I object to the WestConnex M4-M5 Link proposals as contained in the EIS application # SSI 7485, for the reasons set out below.

Application Number: SSI 7485

Application Name: WestConnex M4-M5  
Link

**Figure 7-8** Indicative Darley Road civil and tunnel site (C4) layout

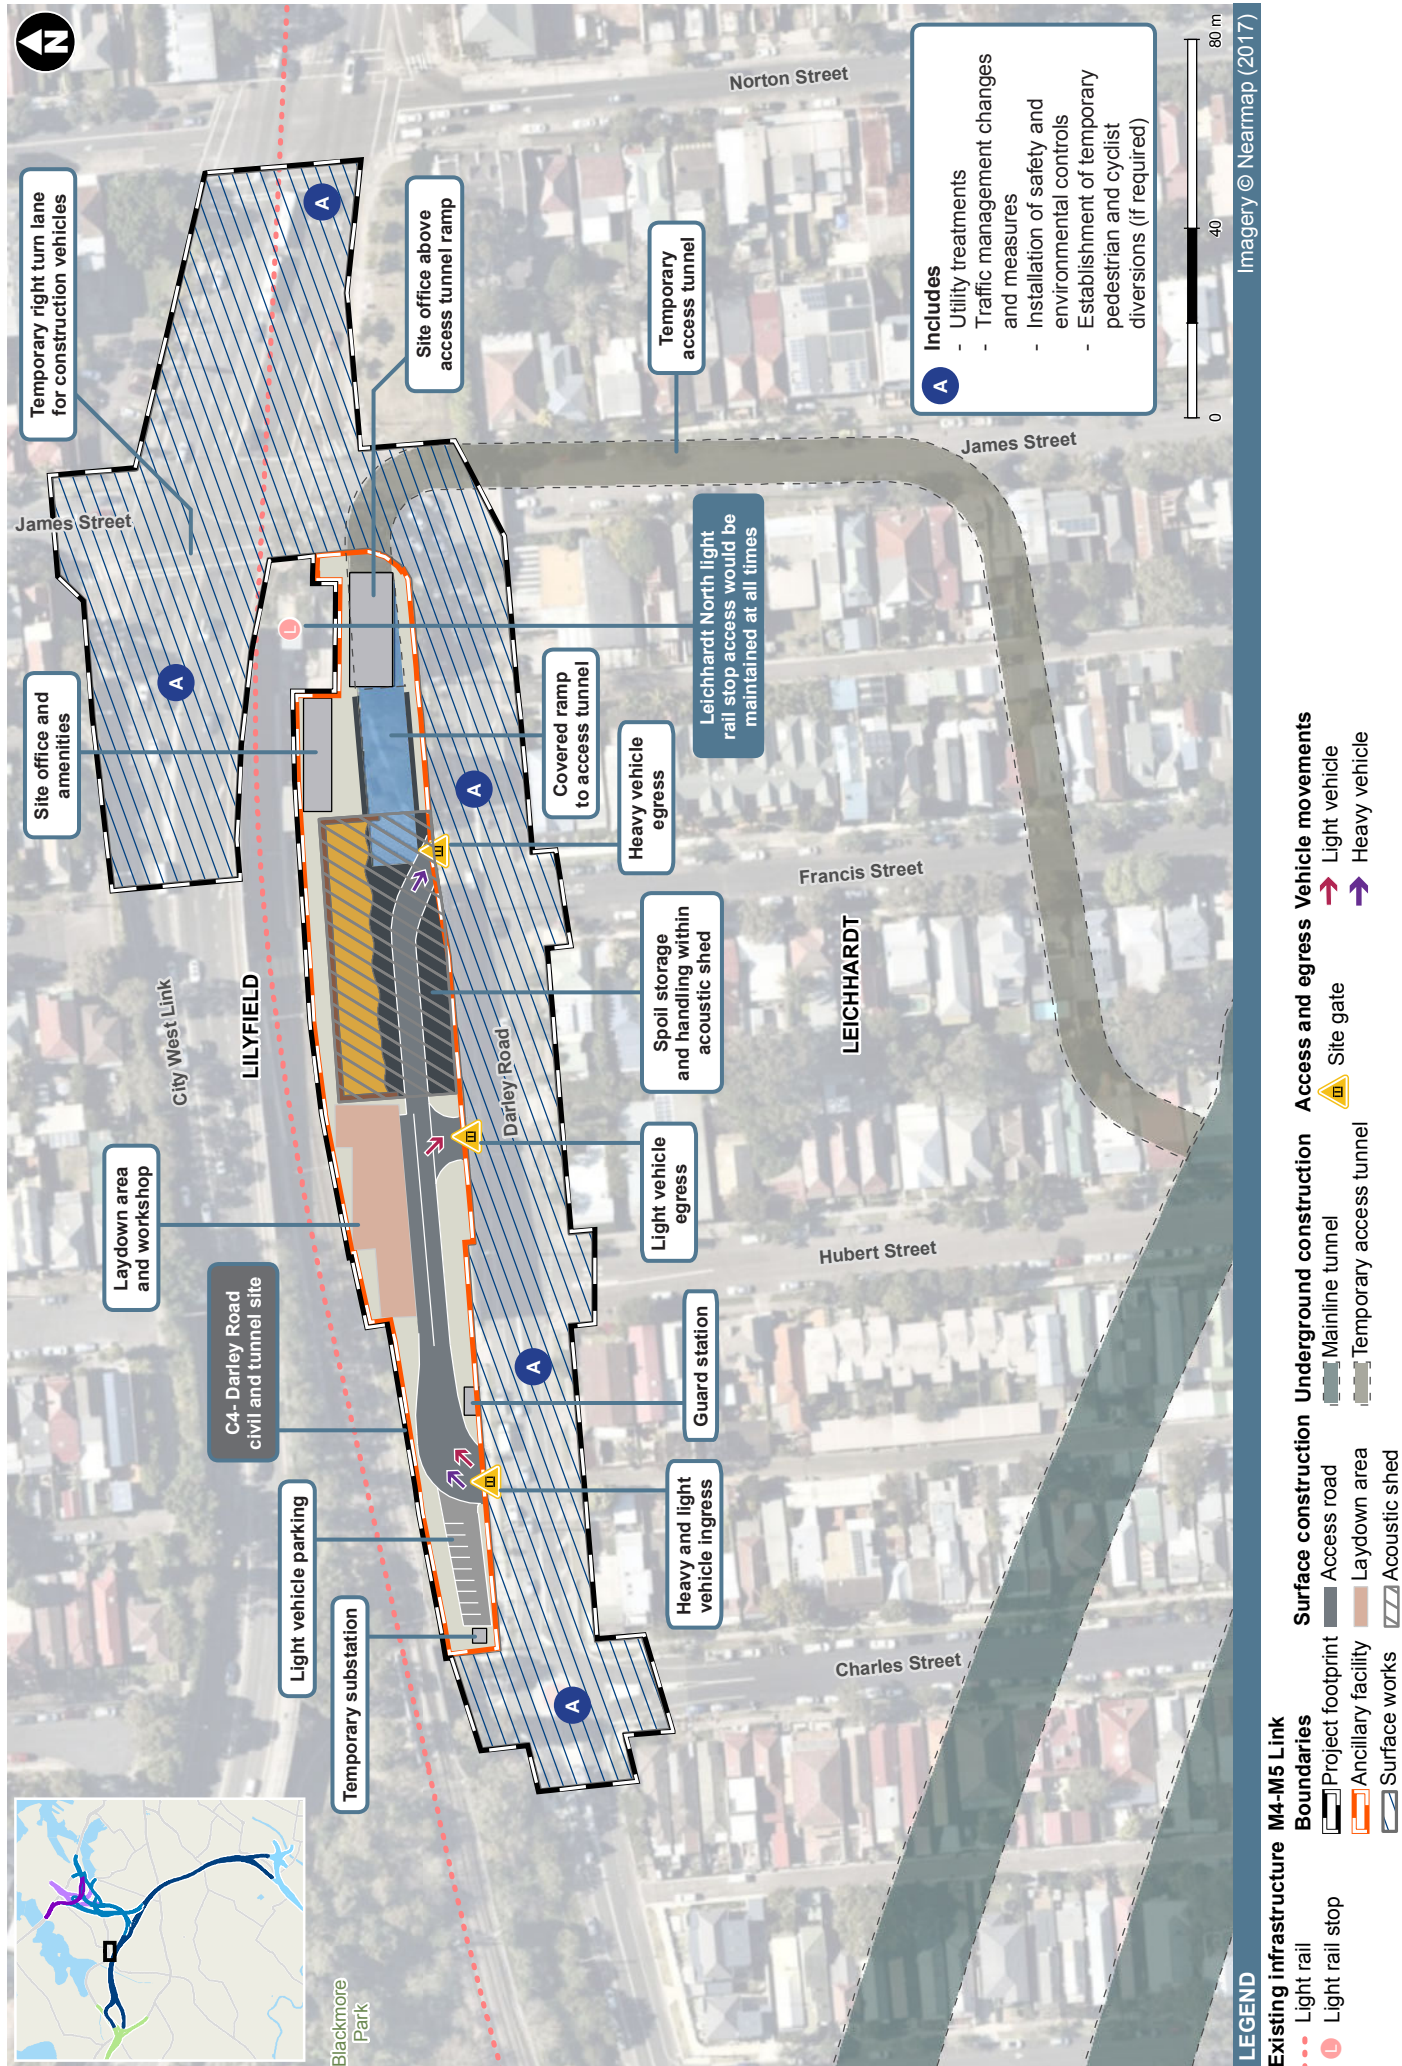
- ◆ There are estimated 100 heavy and 70 light vehicle movements a day and the plan is to allow a right-hand turn into Darley Road from the CW Link. The trucks will drive onto Darley Road, turn right into the site and then left back out onto the CW Link, which is unrealistic given the amount of traffic on these roads now.

- Permanent substation and water treatment plant - Residents on Darley Rd opposite the site and residents in Hubert St will have a direct line of site to the Motorway operation infrastructure. The resultant impact is a permanent degradation of the visual environment, is a loss of amenity and is detrimental to the community. This facility should not be permitted in this location and the EIS needs to demonstrate why it is required at this site. If approved, the facility should be moved to the north of the site out of line of site of residents. The residual land

- Darley Road is confirmed as a 'civil and tunnel site (dive site) with a 'Motorway Operations' site at one end for machinery during the build and will then house permanent water treatment facilities, despite evidence tendered to the Concept Design explaining that this intersection has an high accident rate and is completely unsuitable for such a purpose.
